# MIDDLETON STONEY ROAD, BICESTER.

## PROPOSED PHASE 1B WORKS

### Stage 1 Road Safety Audit

**SG-AA-2024-4431-RSA1**

TITLE
**S278 OFFSITE HIGHWAY WORKS
SECONDARY ACCESS JUNCTION
GENERAL ARRANGEMENT
SHEET 2**

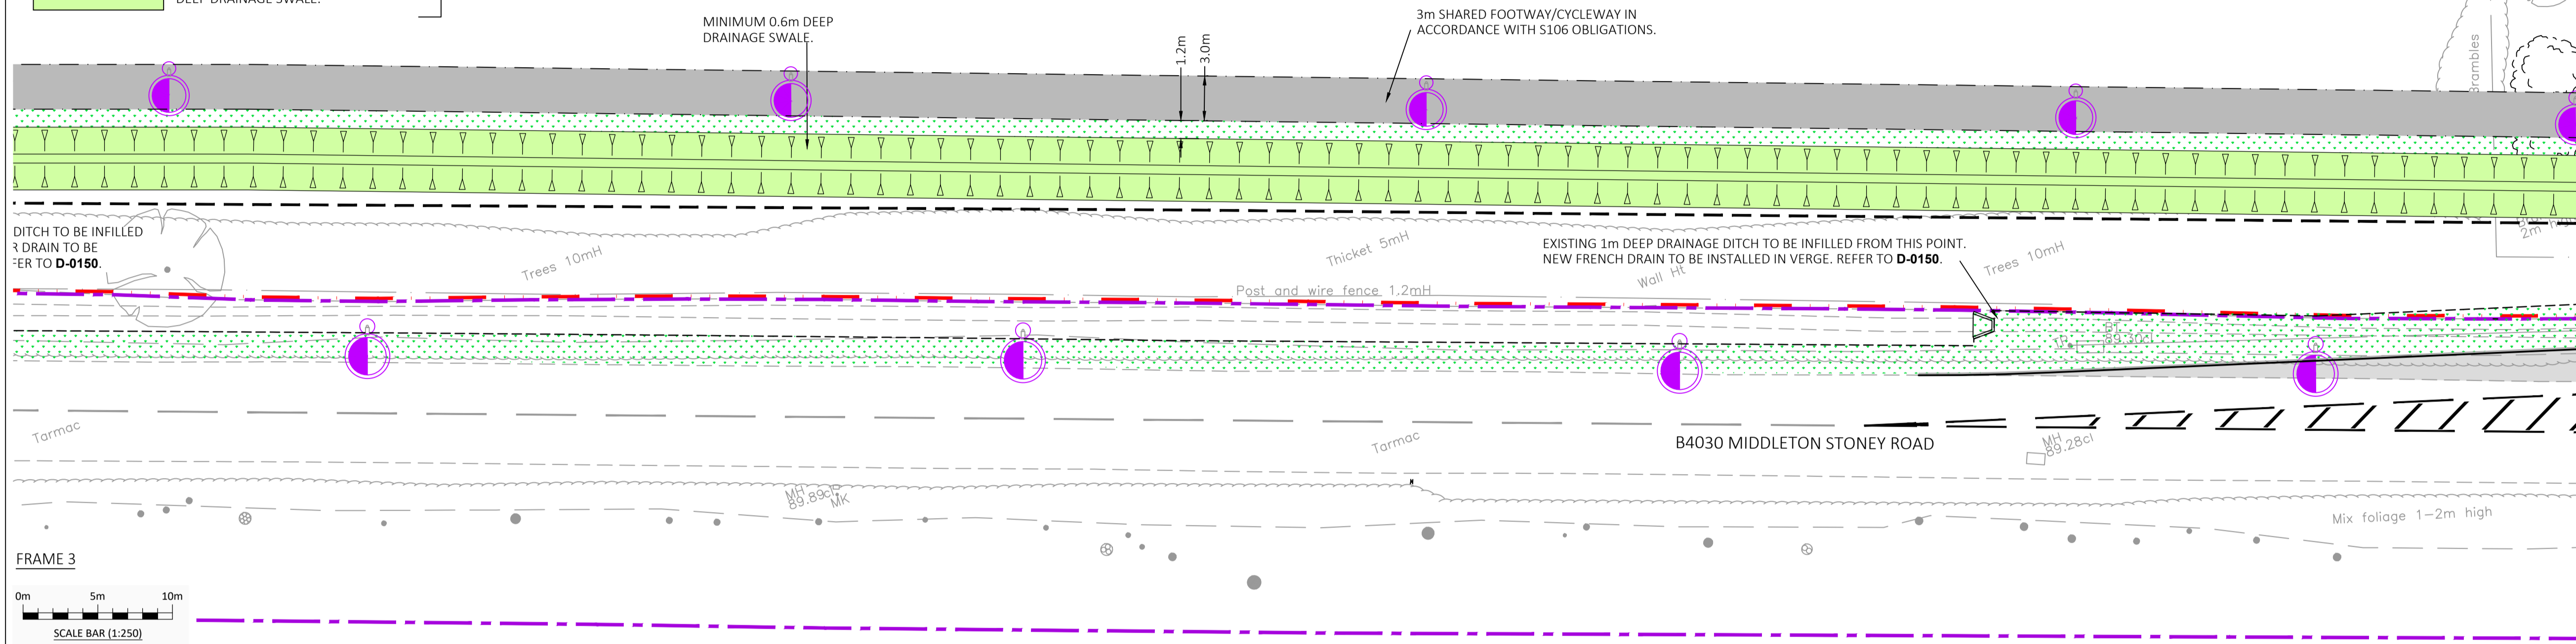
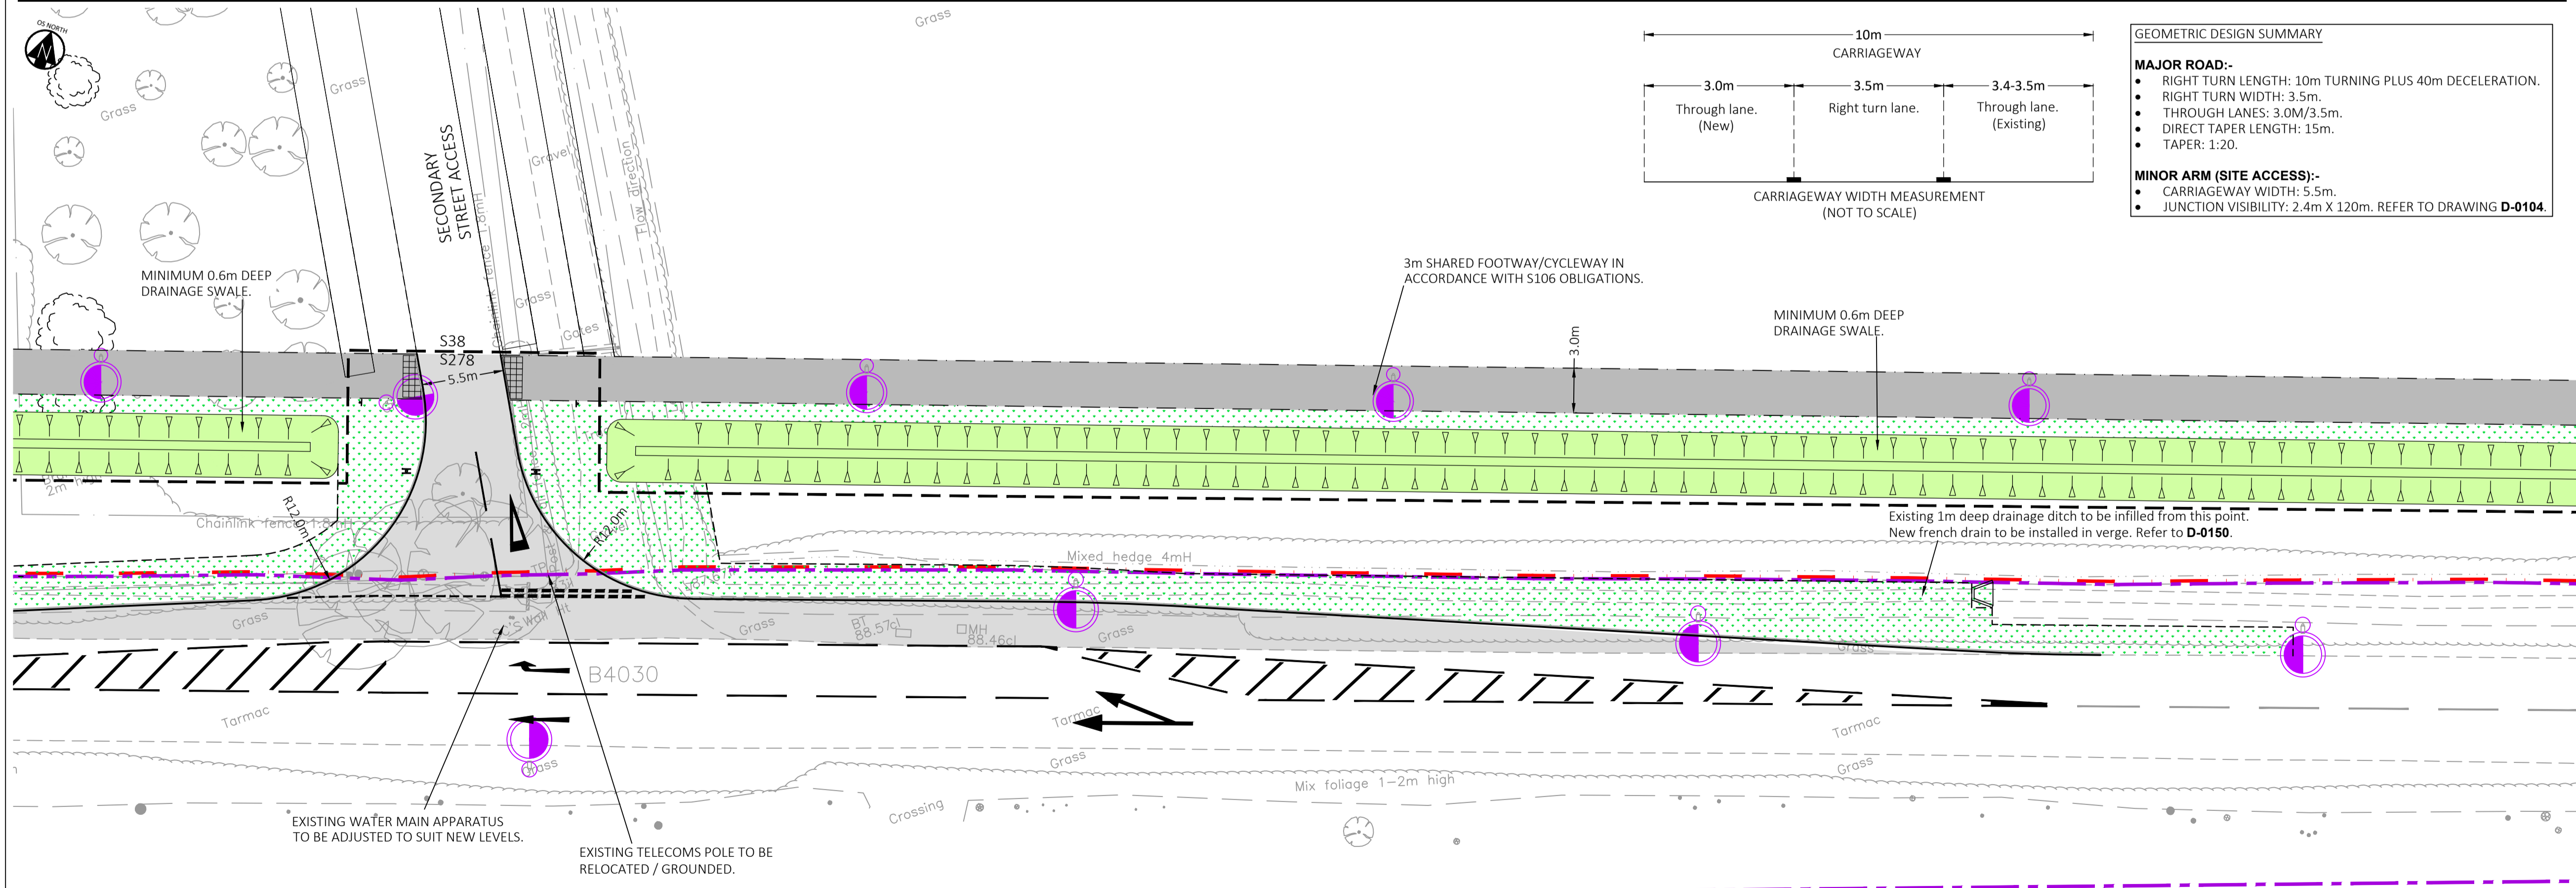
LOCATION: Middleton Stoney Road – Vehicular Access Eastern end

SUMMARY: Insufficient carriageway geometry

From the vehicle swept path analysis provided as part of the scheme submission, it is evident that larger service/refuse vehicle cannot turn left from the site without encroaching onto the right turn lane. Insufficient carriageway widths to accommodate long wheel based vehicular turning movements may increase the risk of vehicle on vehicle side impact/sideswipe type collisions.

LOCATION: Middleton Stoney Road – Eastern Access.

SUMMARY: Risk of vehicle overhang on mainline carriageway.

It is unclear from the drawings provided whether there will be sufficient carriageway width between the edge of the give-way and the mainline carriageway of Middleton Stoney Road. Insufficient width may result in vehicles entering the proposed access overhanging the mainline carriageway when stopped to give-way to cyclists at this location. This may increase the risk of vehicle on vehicle side impact type collisions and possible injury to vehicle occupants.

The Audit Team recommends providing adequate carriageway geometry to ensure that all likely vehicle types to use this junction can carry out turning safely and without obstruction.

The Audit Team recommend that sufficient carriageway length is provided between the proposed give-way and the mainline carriageway to accommodate all vehicles expected to use this junction.
